From: Laura Gibbons <Laura.Gibbons@arun.gov.uk>
Sent: 19 April 2022 14:43
To: Planning.Responses <Planning.Responses@arun.gov.uk>
Cc: Simon Davis <Simon.Davis@arun.gov.uk>
Subject: RE: Planning Re-Consultation on: AL/29/22/DOC

Engineers Further Comments on Condition 11

Application No: AL/29/22/DOC

Site Address: Land At Wings Nursery Lidsey Road Woodgate PO20 3SU

Drawing Title Existing Watercourse Alterations General Arrangement and Levels

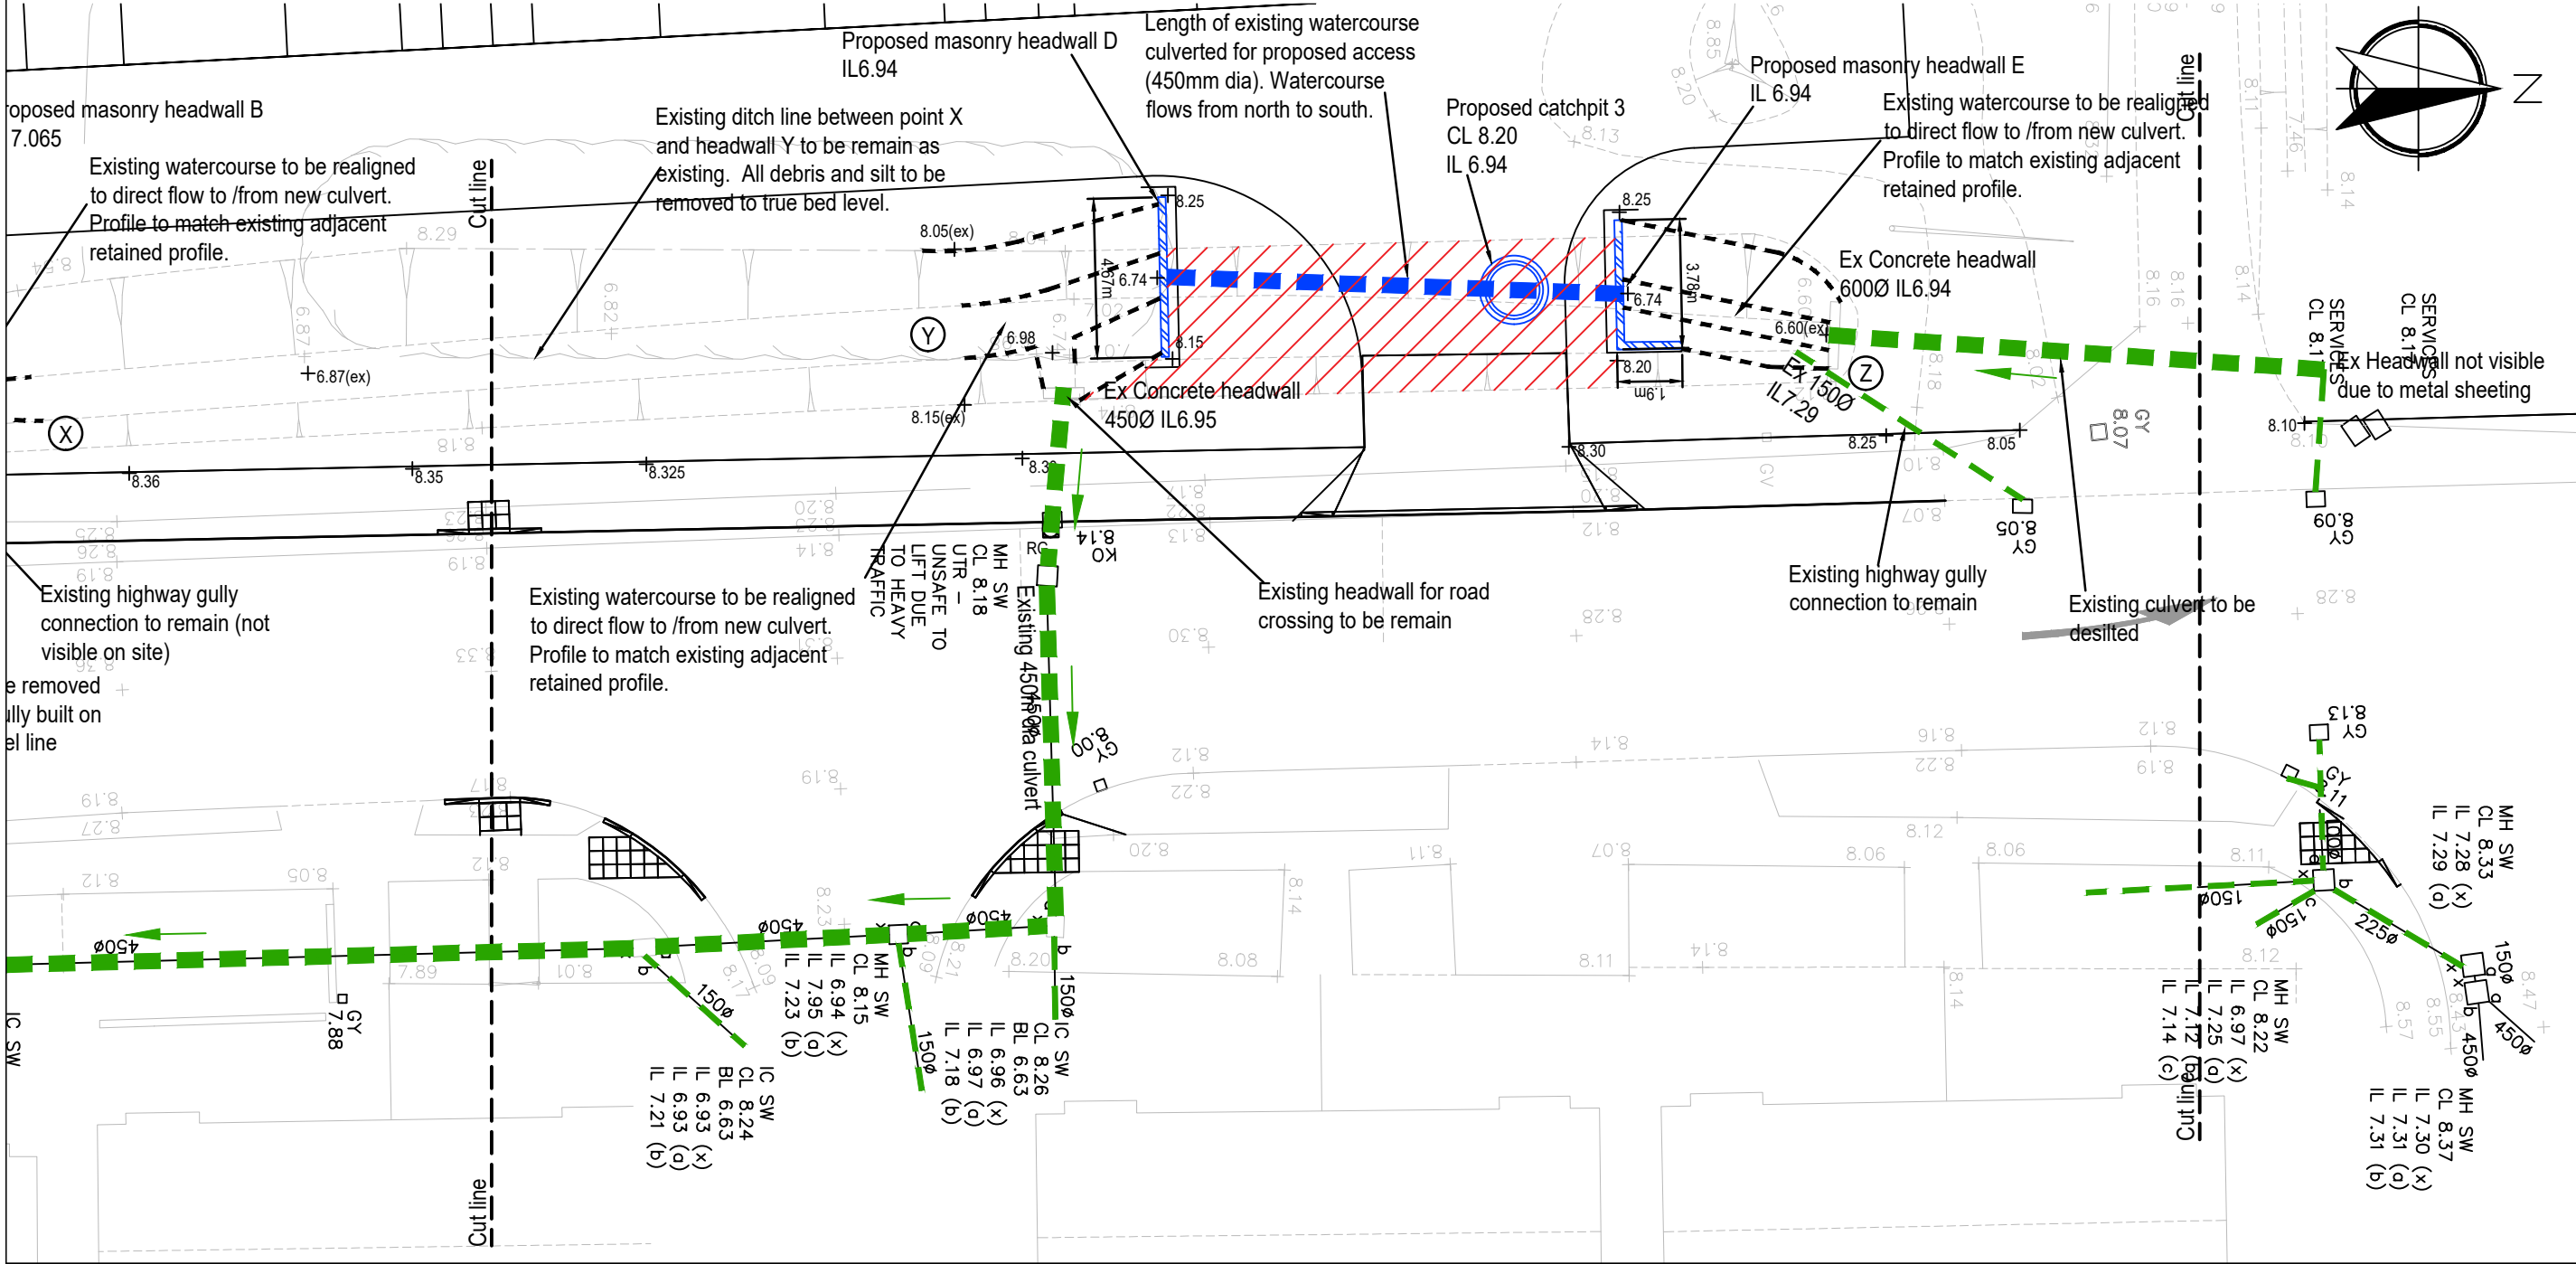
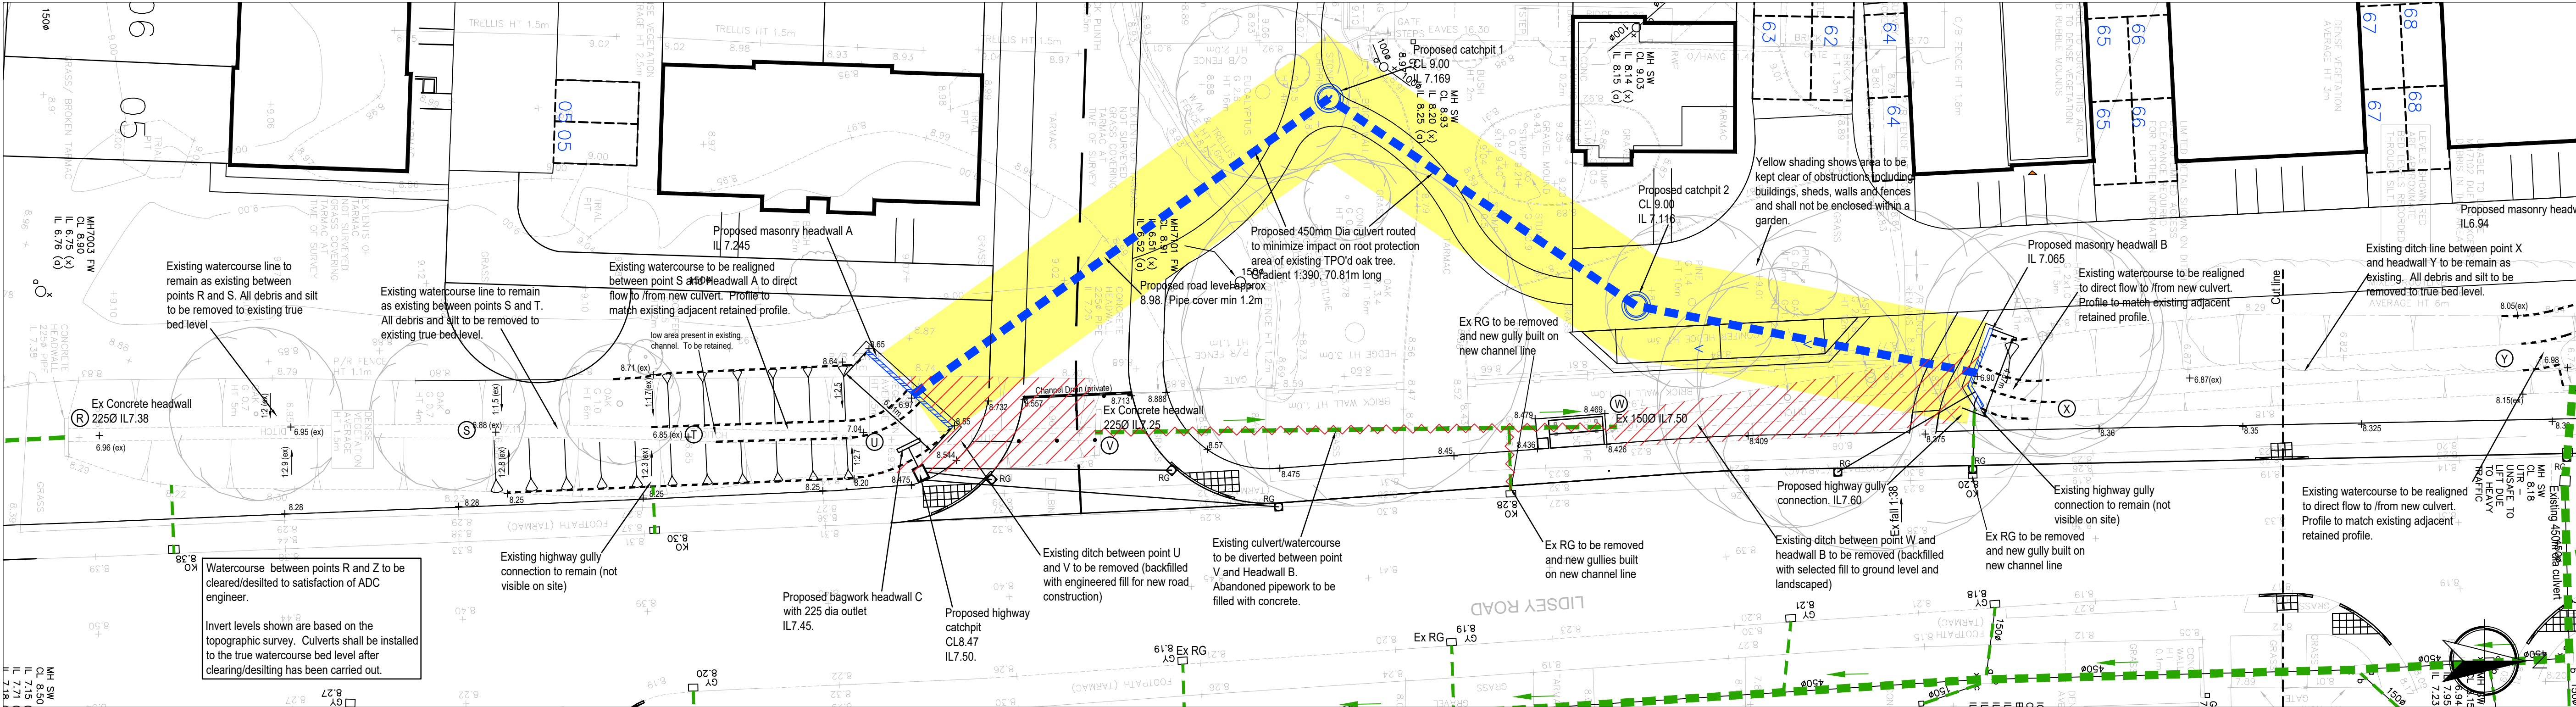
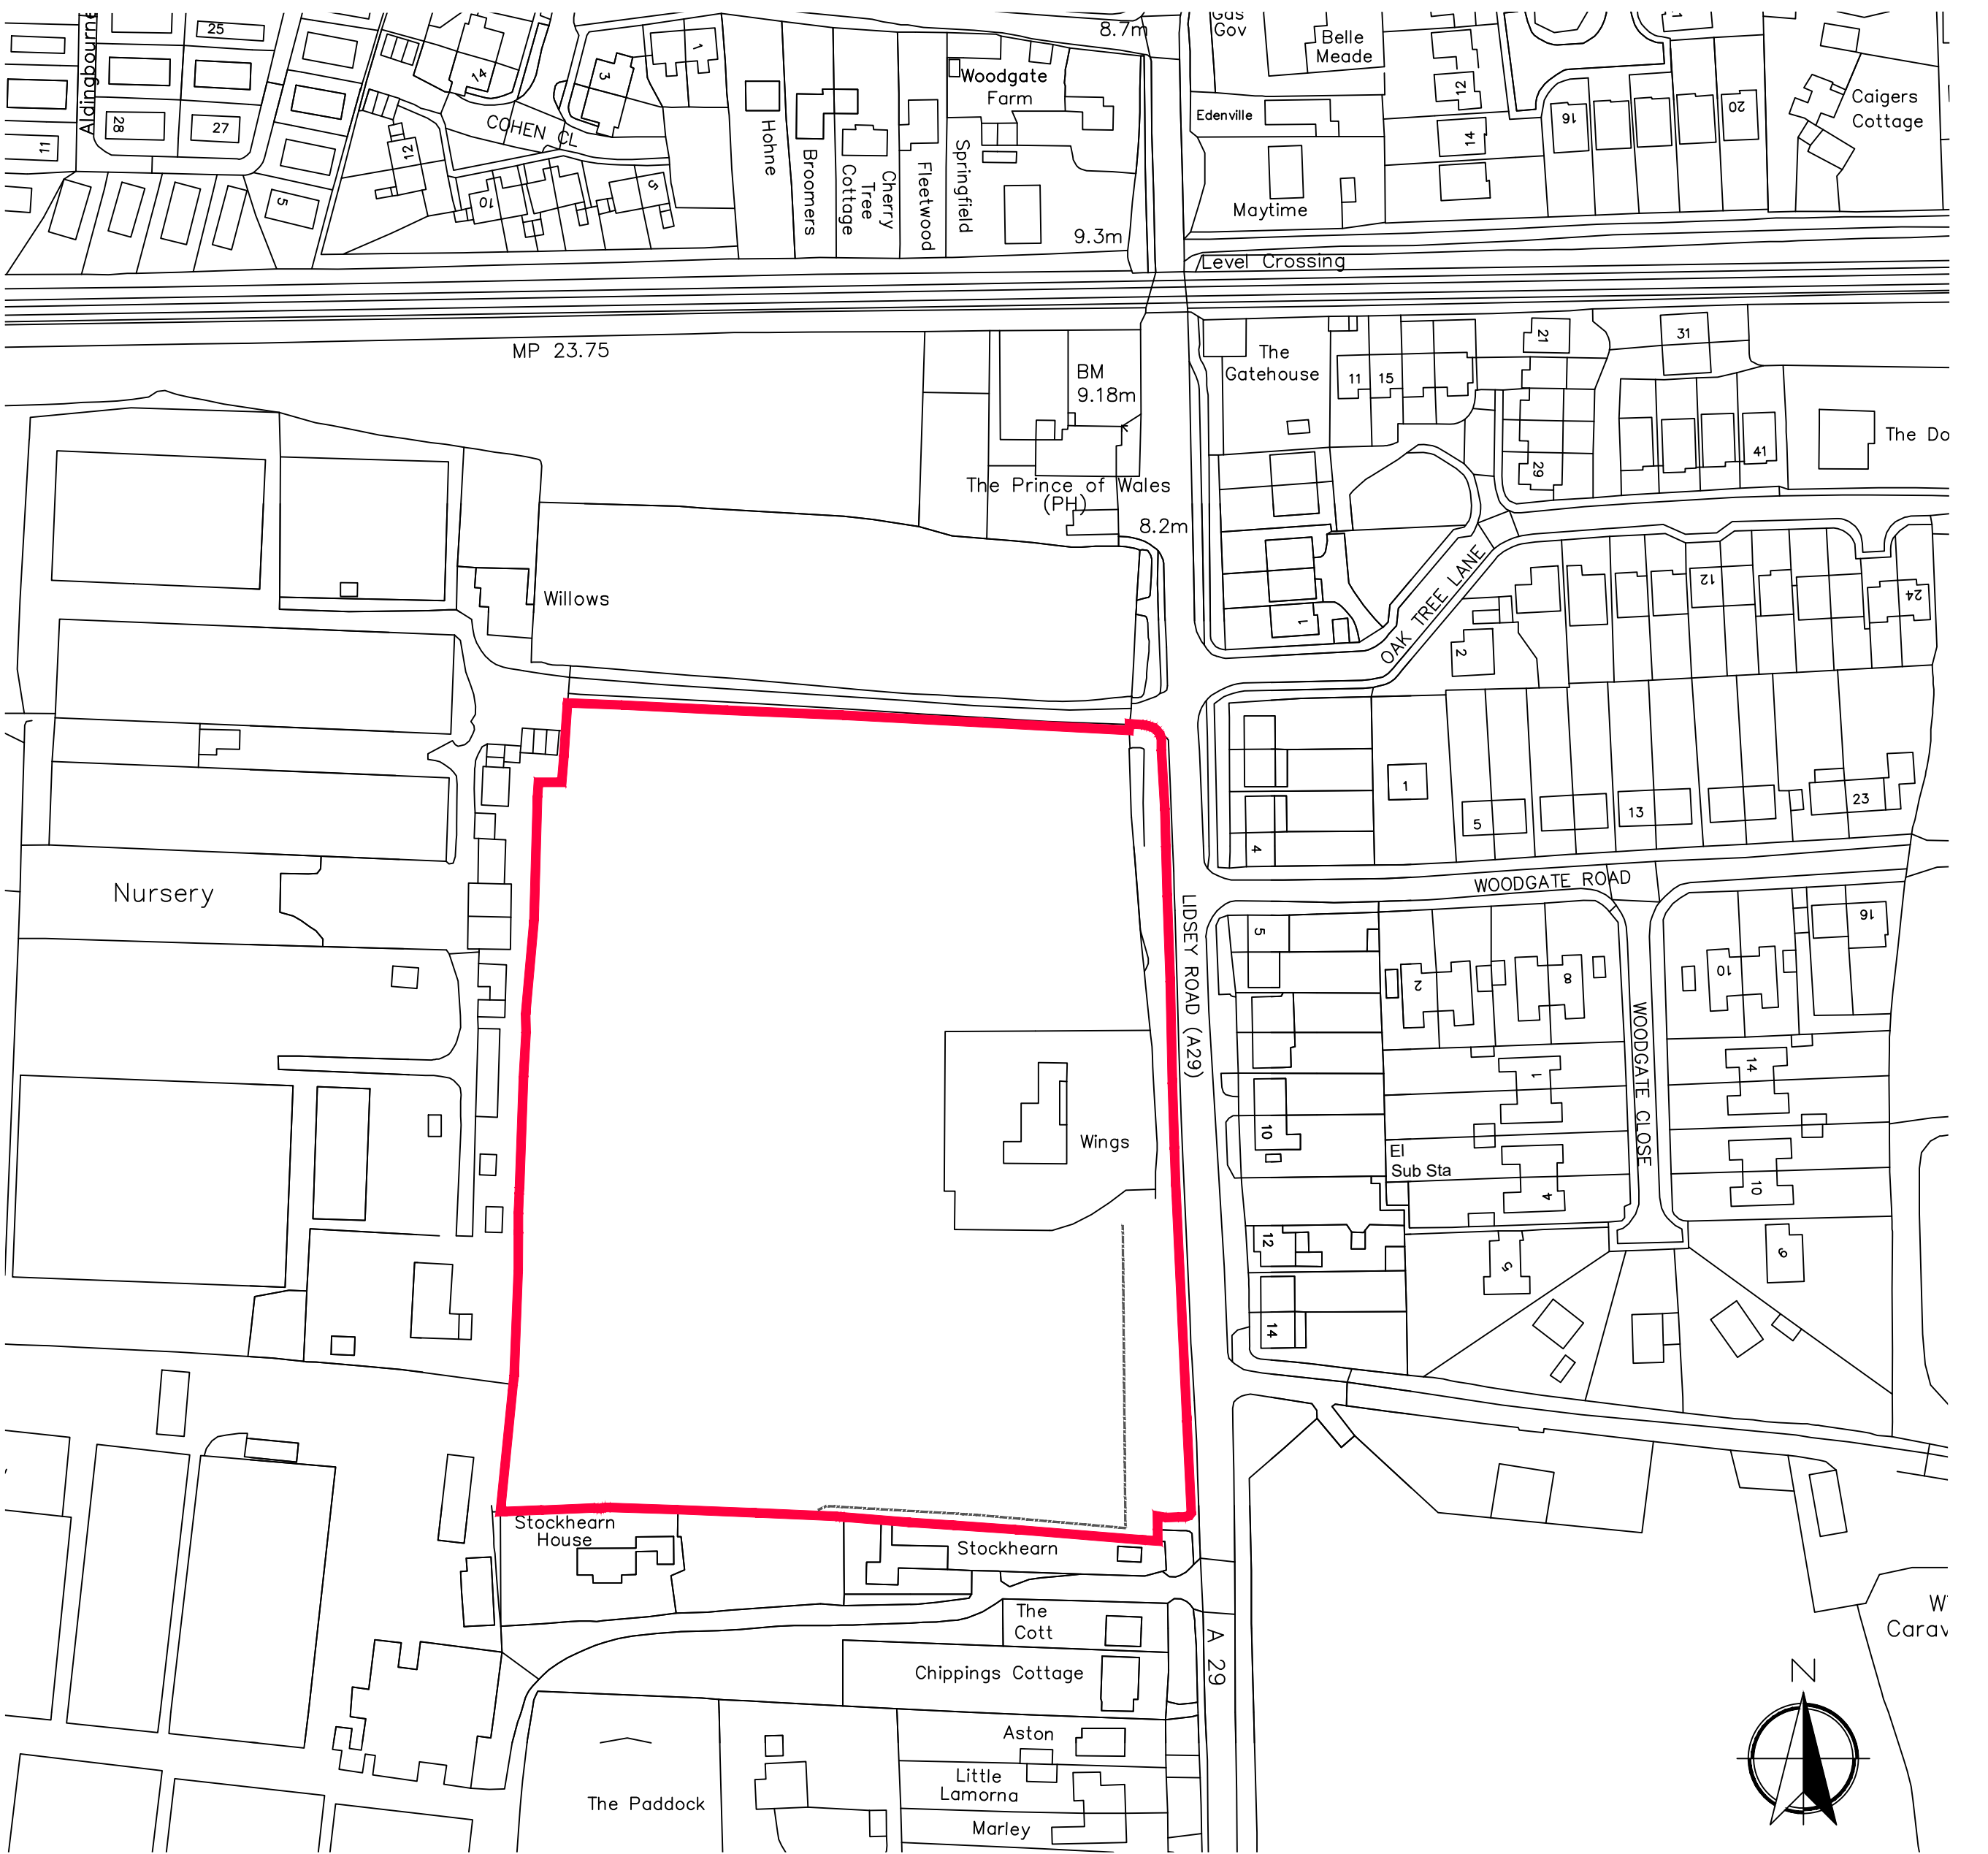
It is noted that an extension has been granted for LDC/ARUN/2021/002. However, this land drainage consent does not include consent for the new drainage connections. Please apply for land drainage consent for the two new outfalls, i.e. for the proposed connection to the new culvert and for the proposed headwall further north on the open watercourse. Please supply evidence of consent.

Please also confirm if it has been verified if there is any culvert outlet for the ditch on the western boundary?
